Ref: SY180766-SEL02-B

The intent of this letter is to provide responses to queries raised by The City of Sydney and the NSW Government Architect regarding the Development Application at 11 Gibbons Street in Redfern, NSW. Our response to these queries are as follows:

SY180766-SER01: SGCH Gibbons Street, Redfern

Drawing Number
Revision
DA2005
C

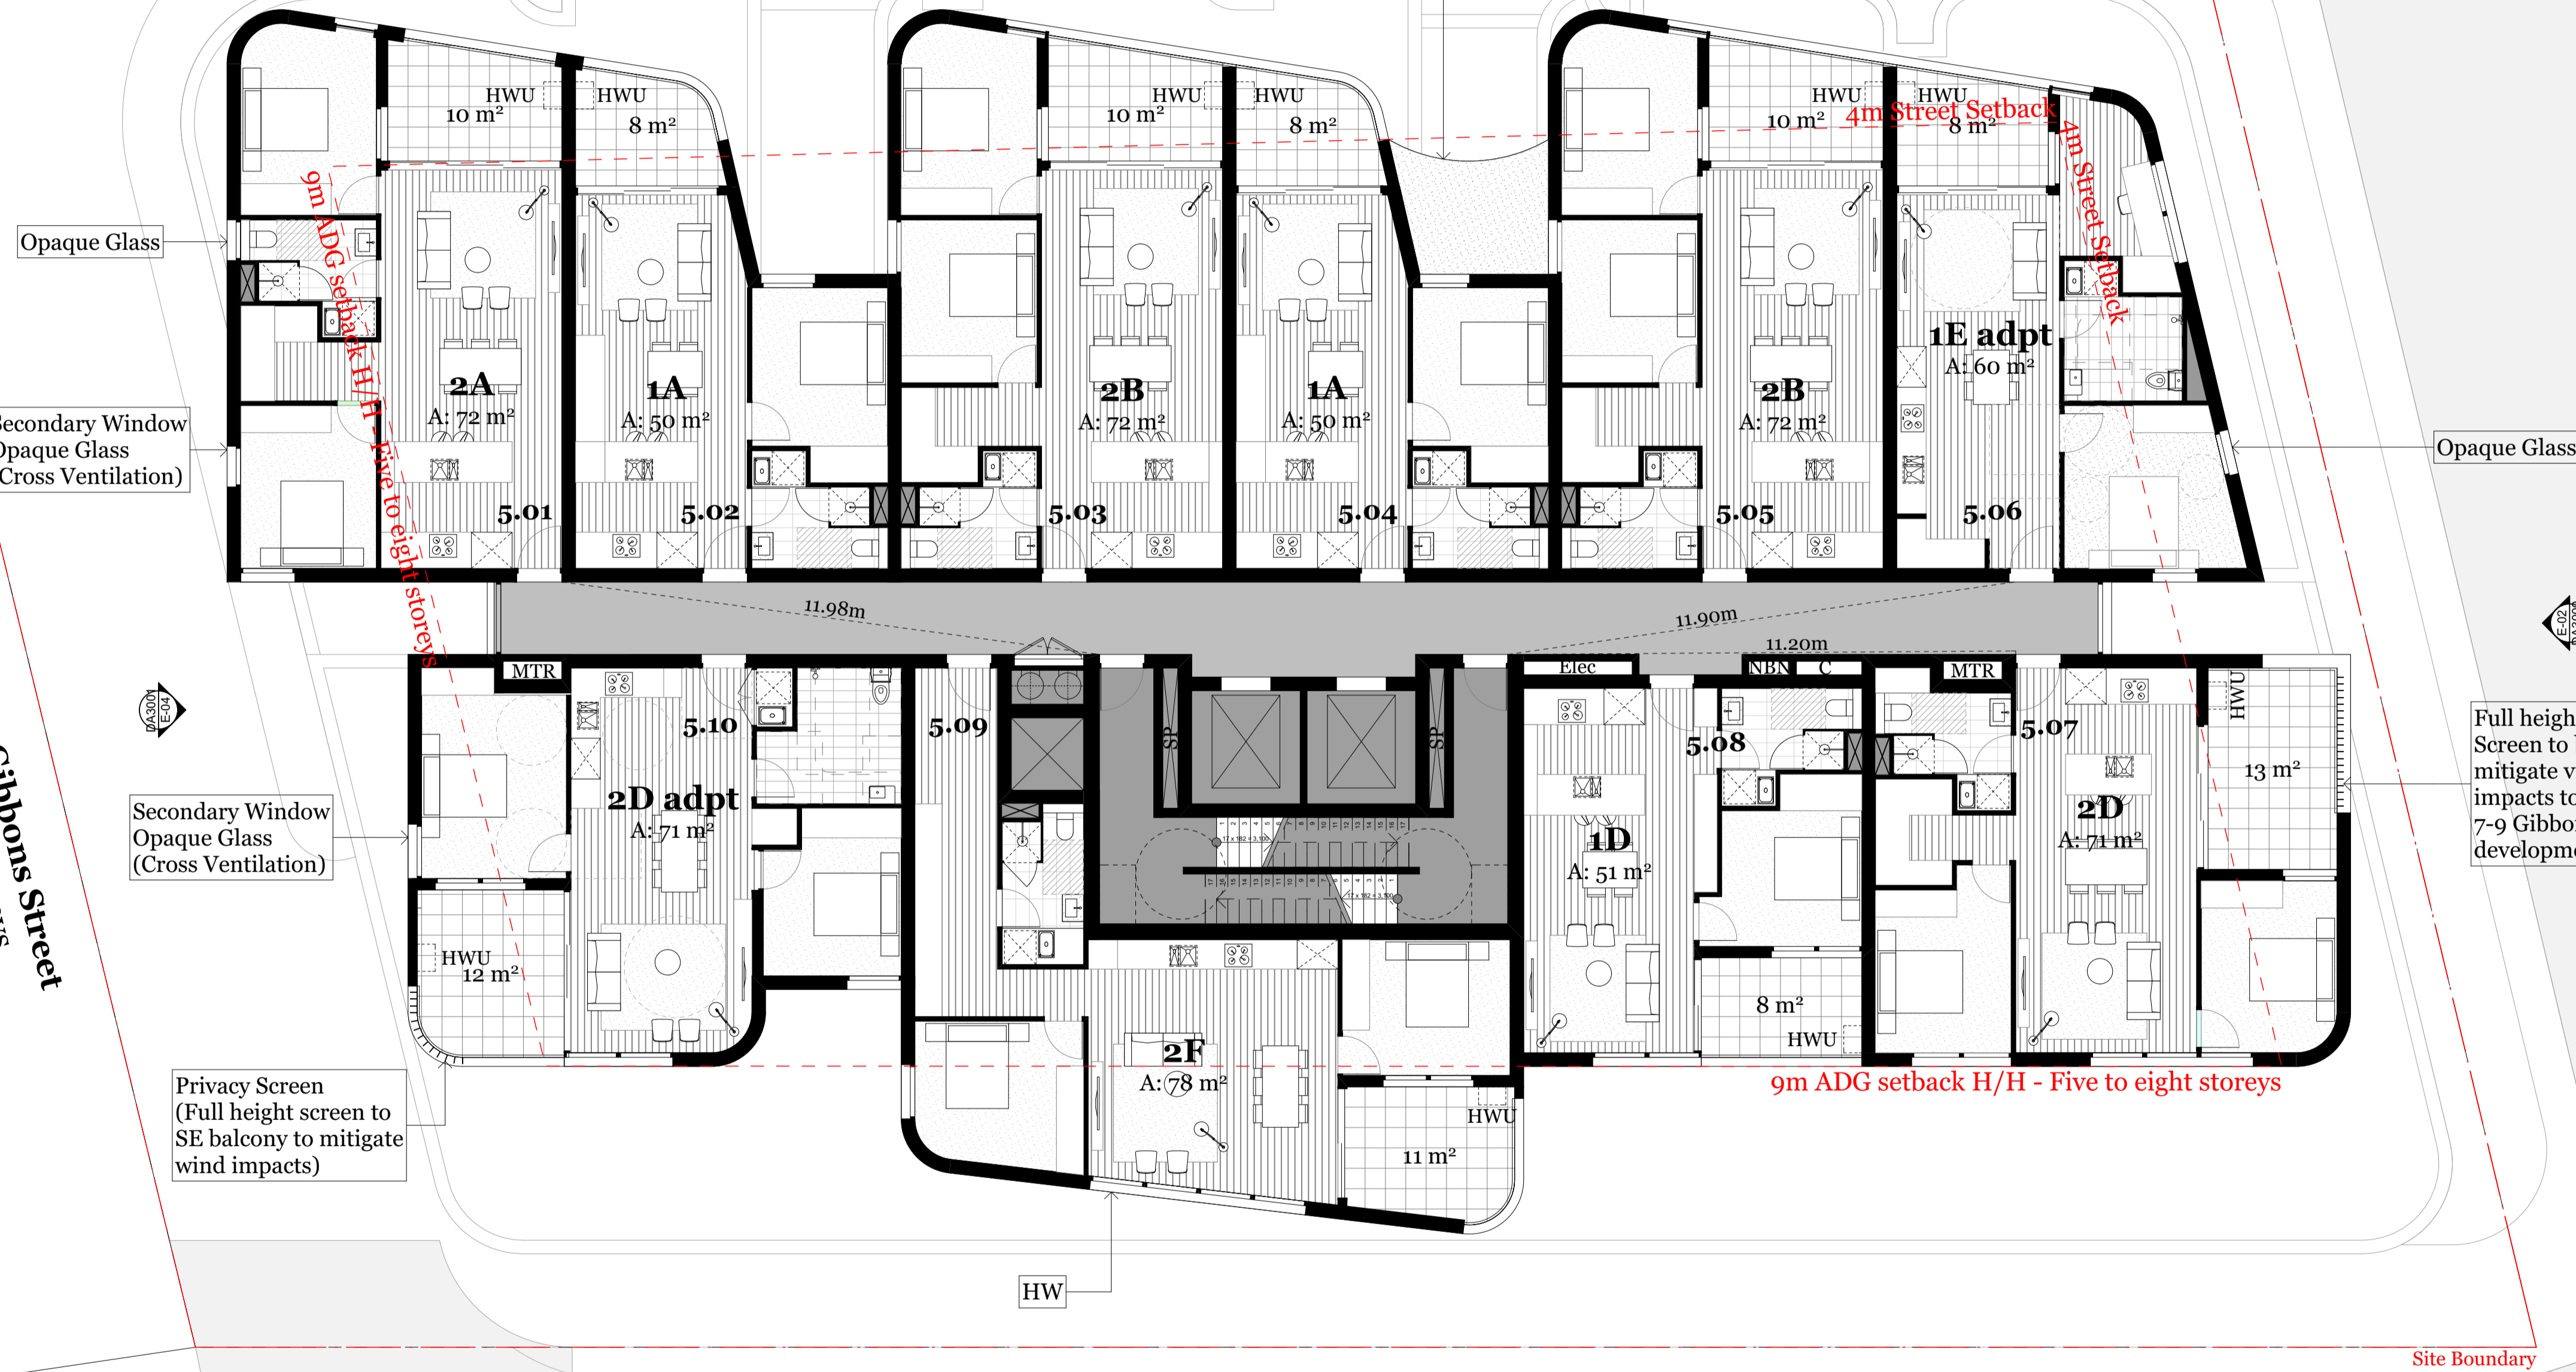
The units contain large balcony overhangs that act as horizontal shading devices to the kitchen/living area sliding doors. Horizontal shading devices are deemed the most effective at reducing solar heat gain to the units.

TITLE
MECHANICAL SERVICES
WINDOW VENT DETAILS

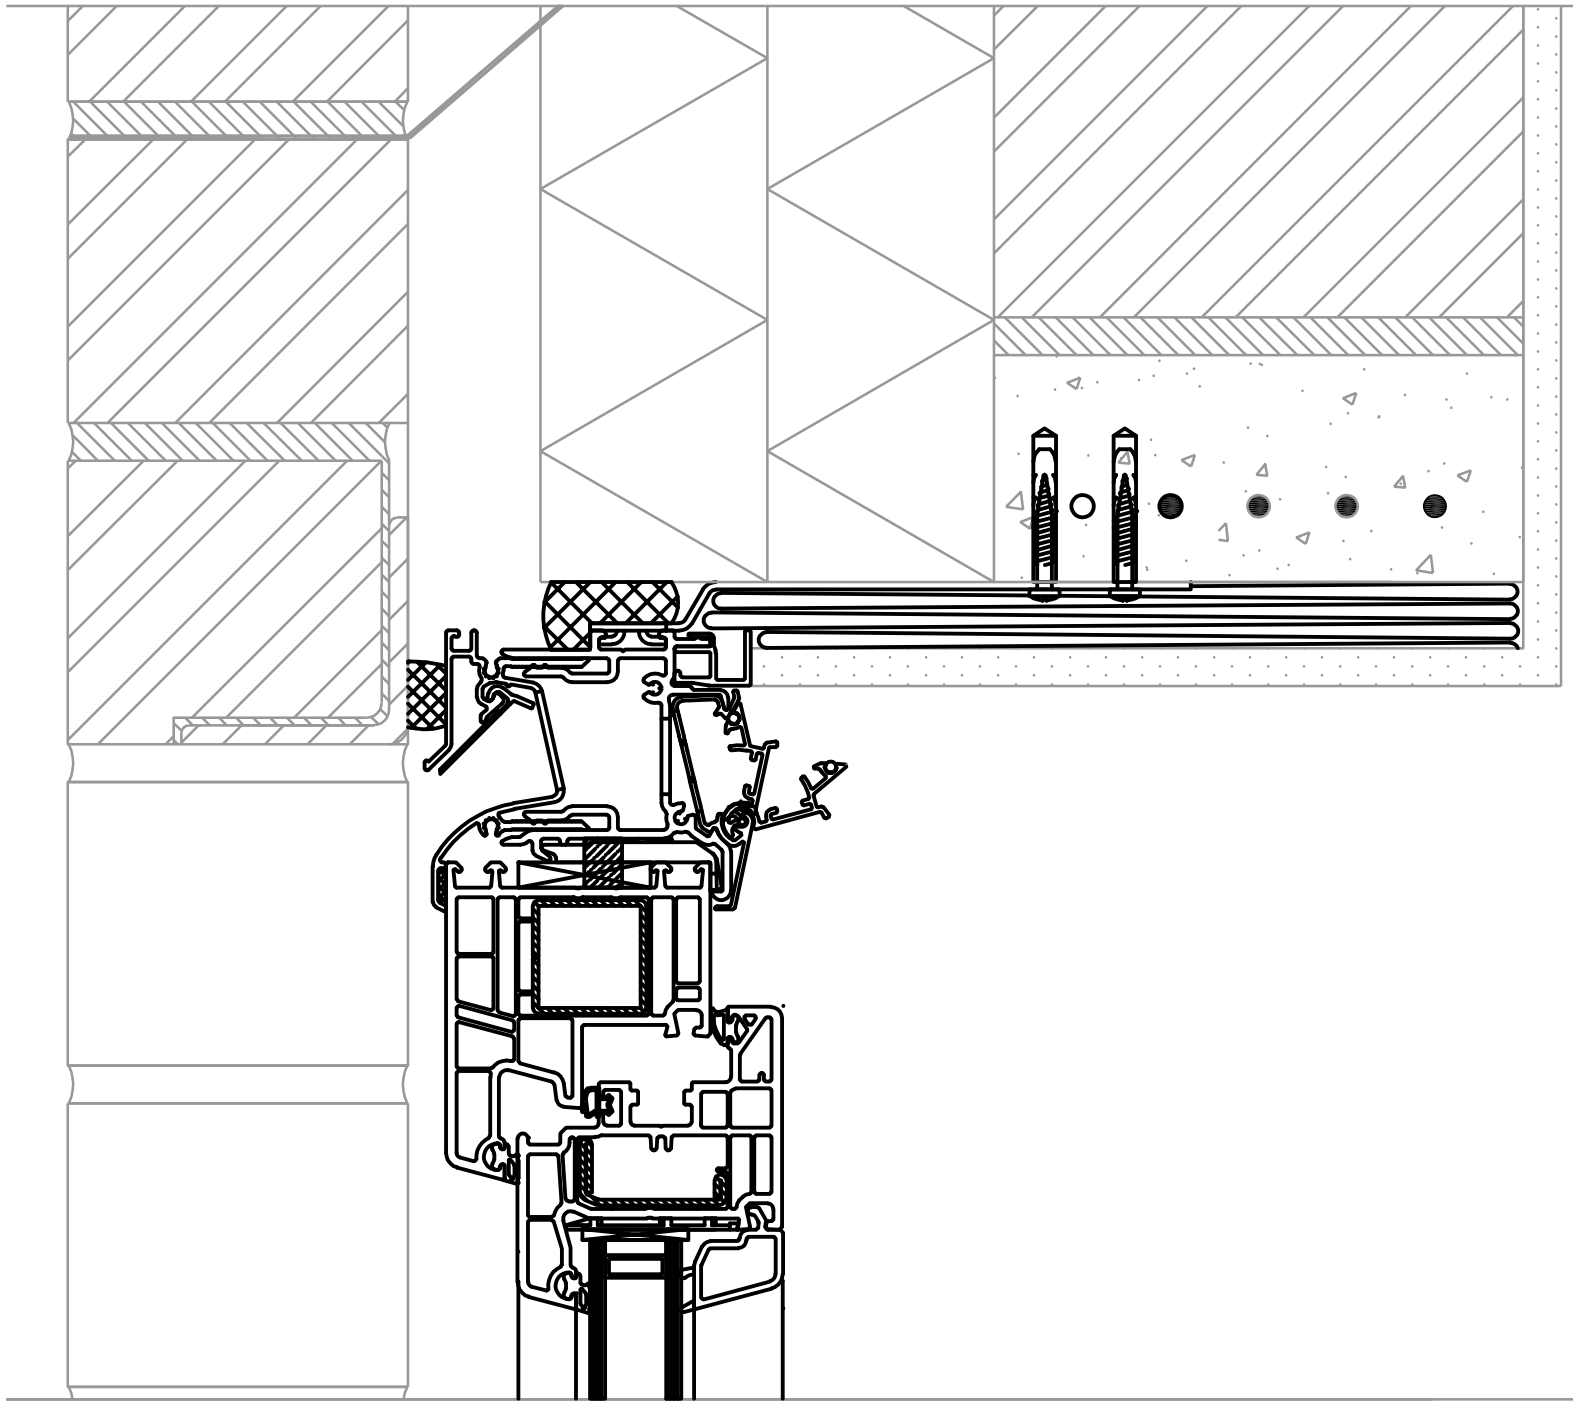
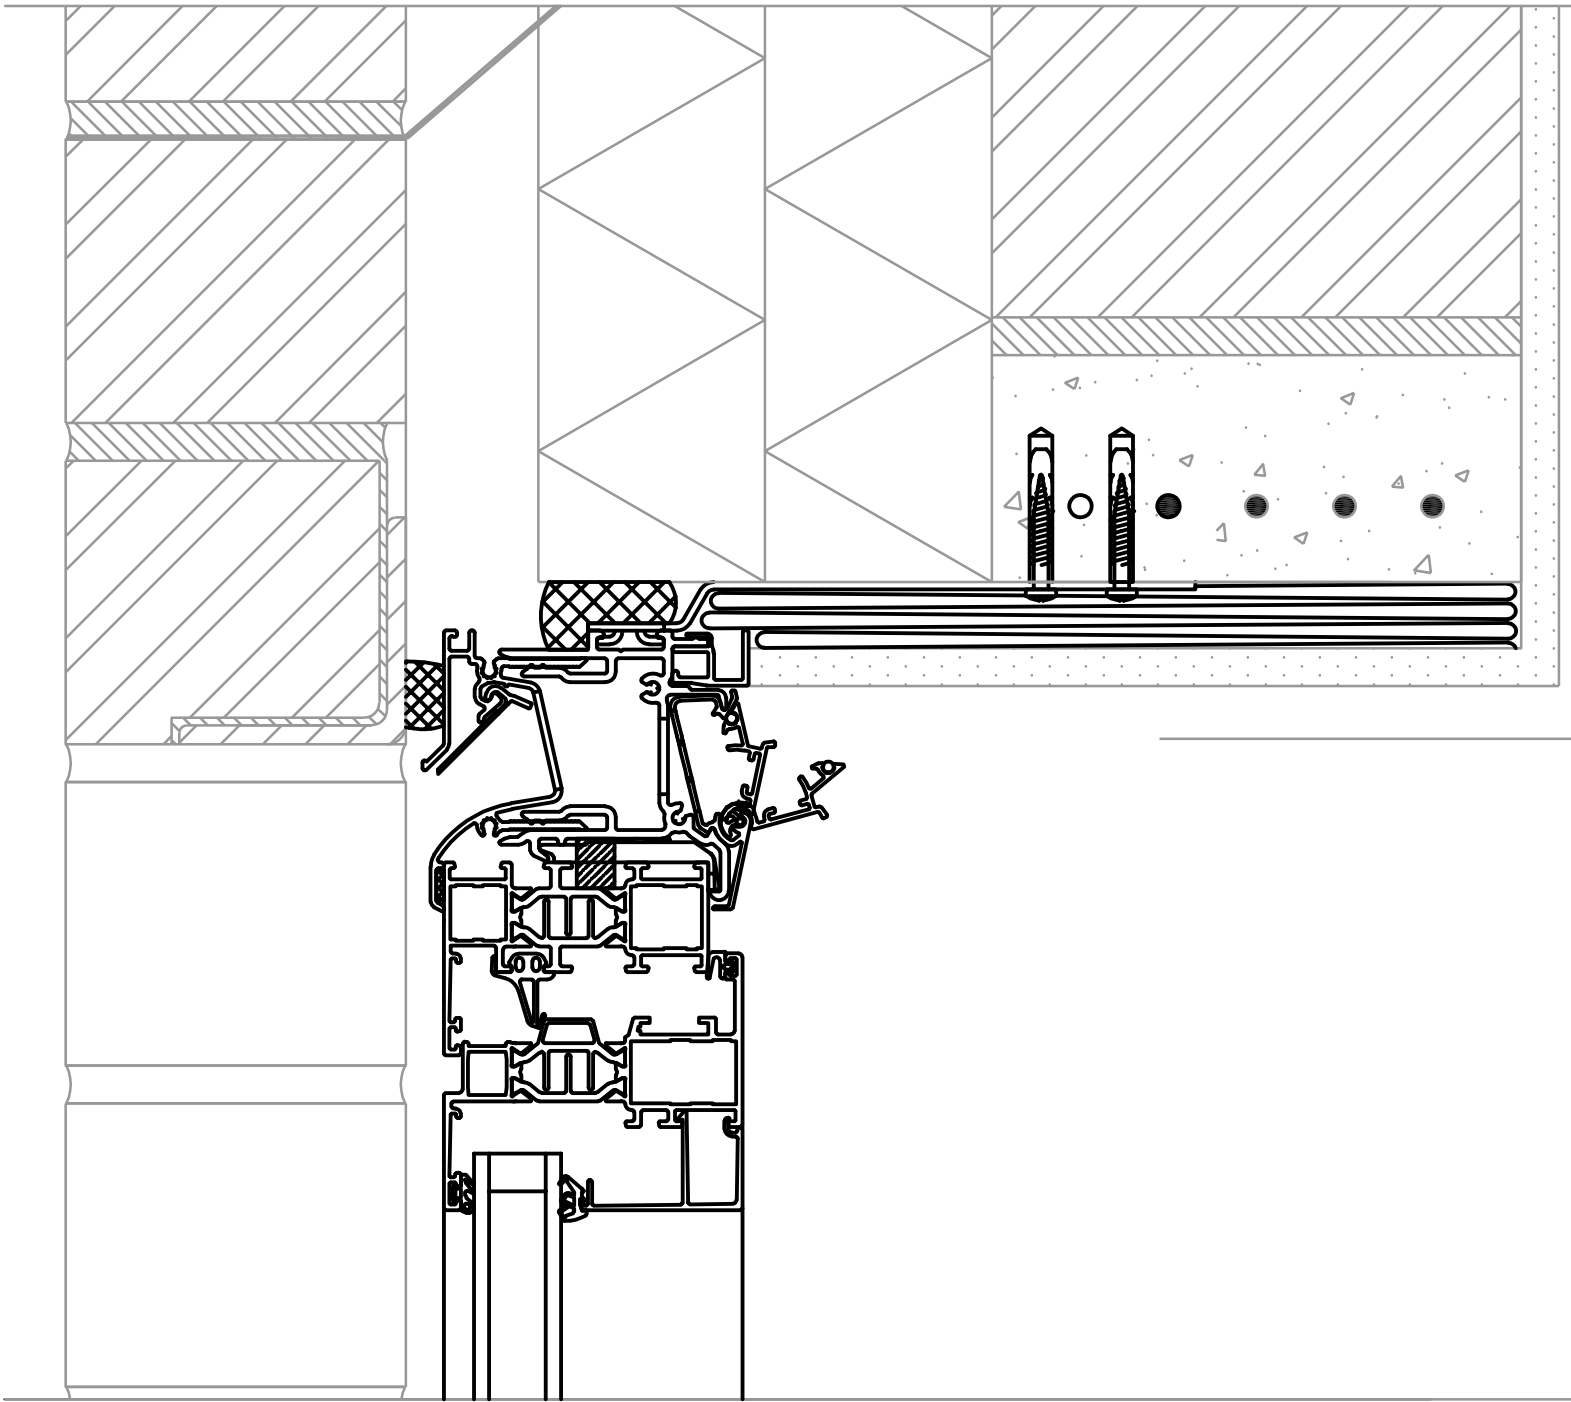
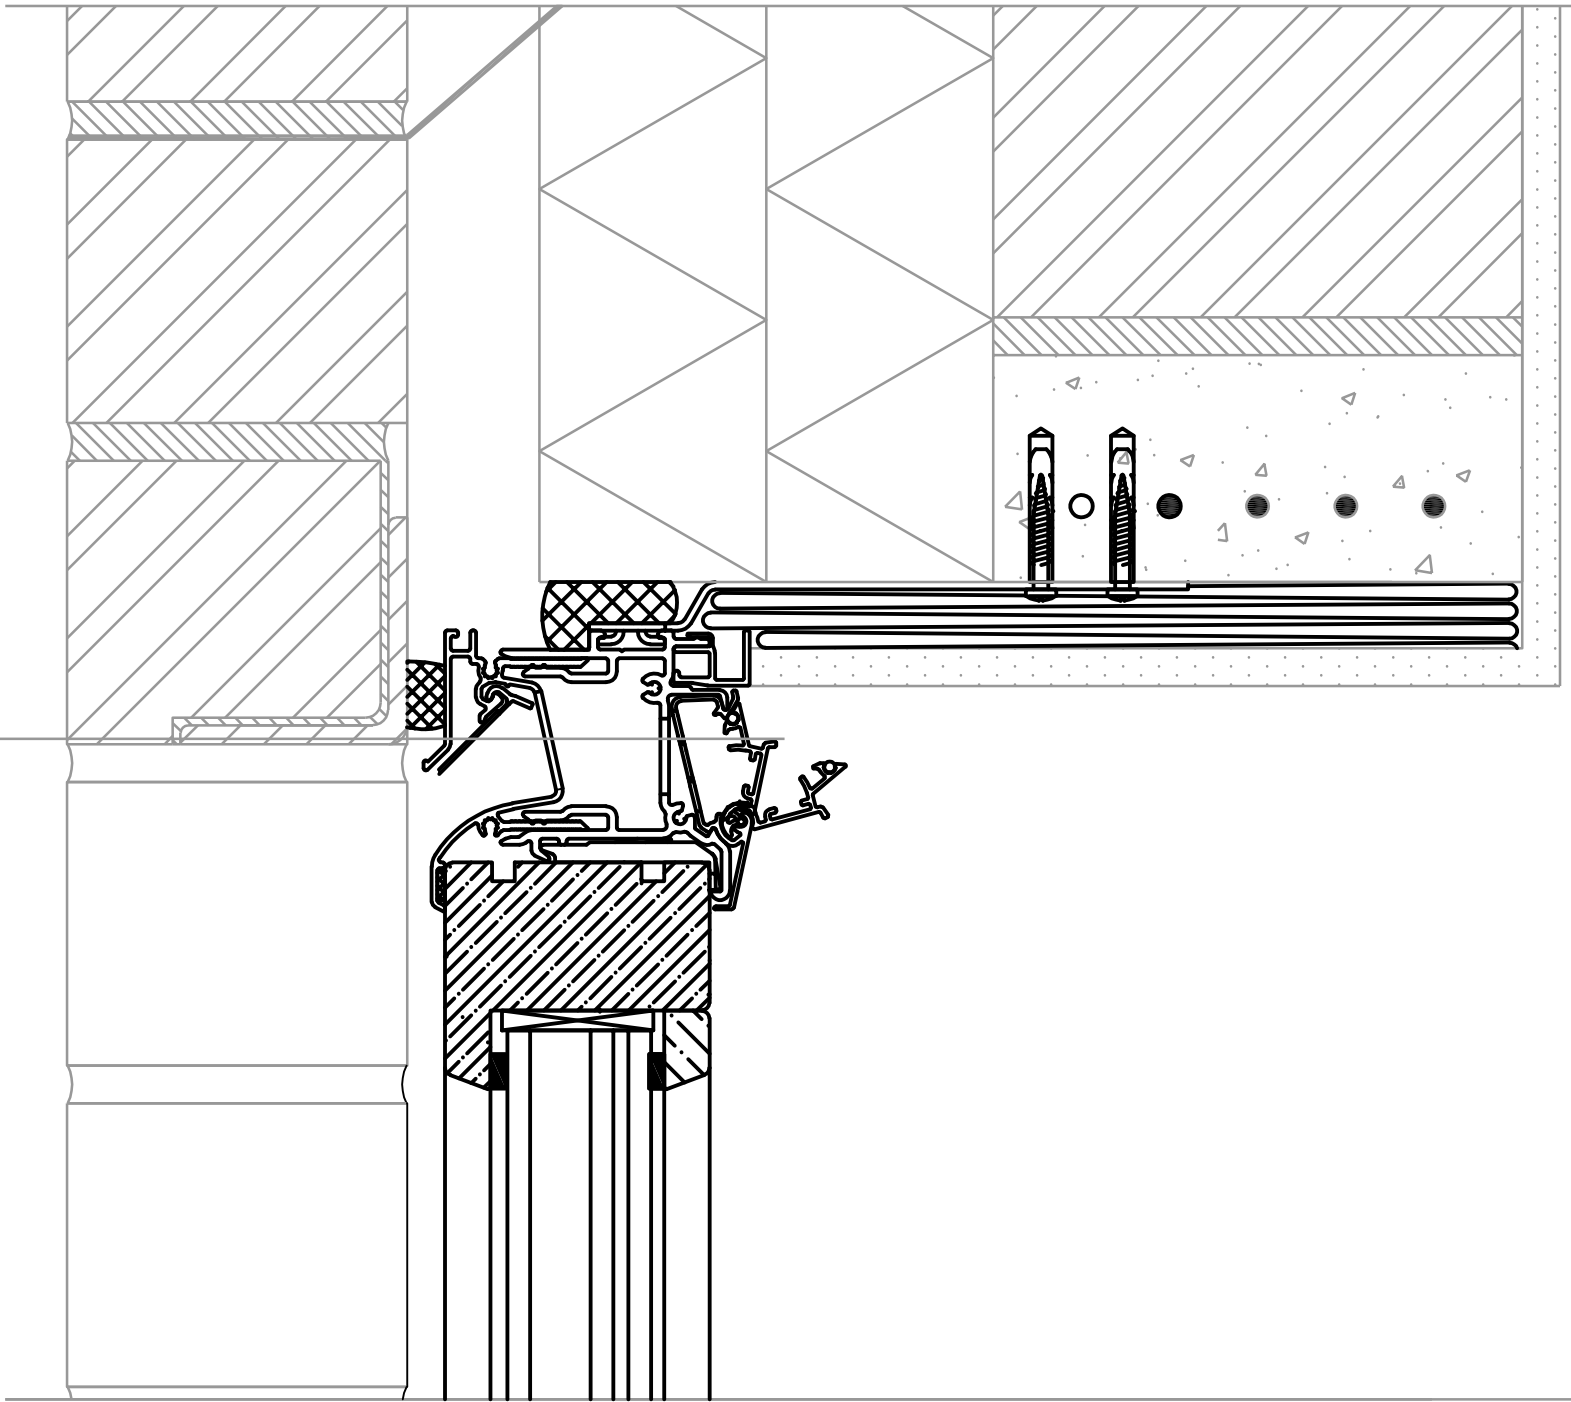
7. Natural Ventilation (Government Architect Query)

Please see point 3. The mechanical engineer should be approached for further technical details regarding the method of natural ventilation in the units.
